## **M54 to M6 Link Road M54 - National Infrastructure Planning**

Further to my letter of 18 May 2020, registering as an Interested Party, I would like to make the following more detailed representations on behalf of my constituents:

Drawing Title
**FIGURE 6.8
HILTON PARK 1842**

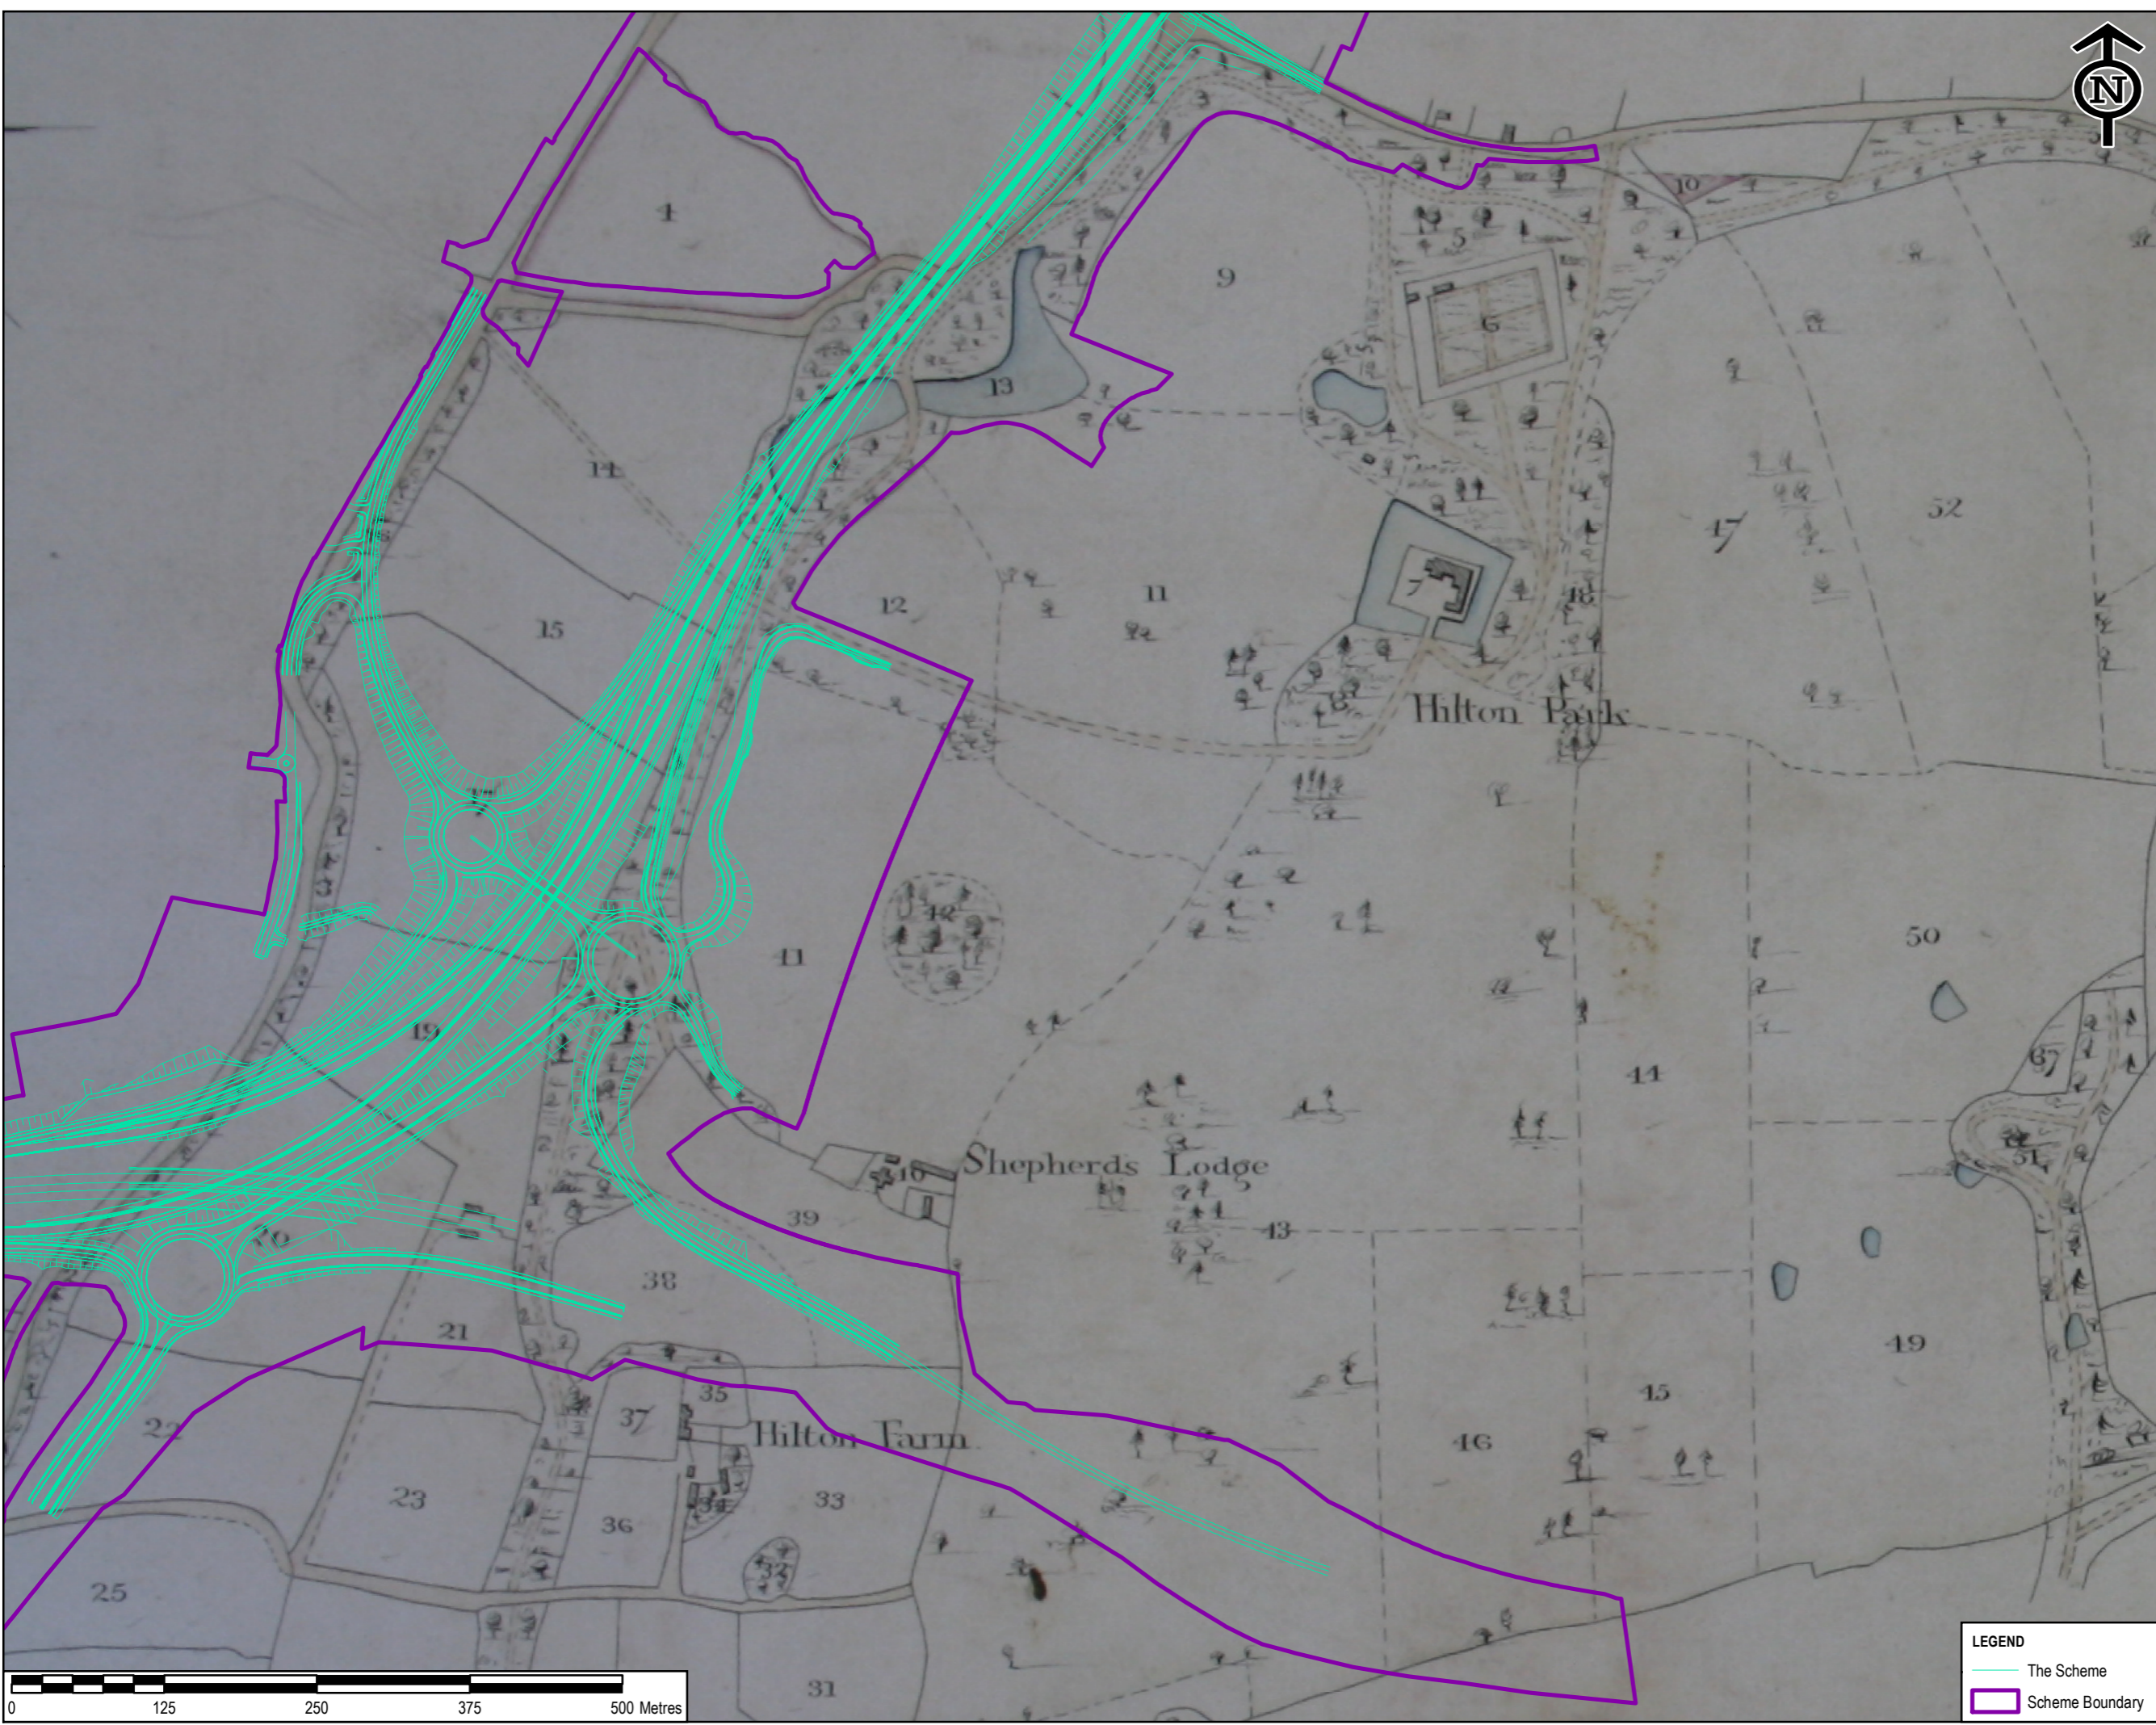
- Vibration from the volume of traffic.
- Change of street scene and loss of amenity including views to Hilton Park.
- The close proximity of the road nearest to the residents of Dark Lane/Park Road and the scope for an eastward realignment.
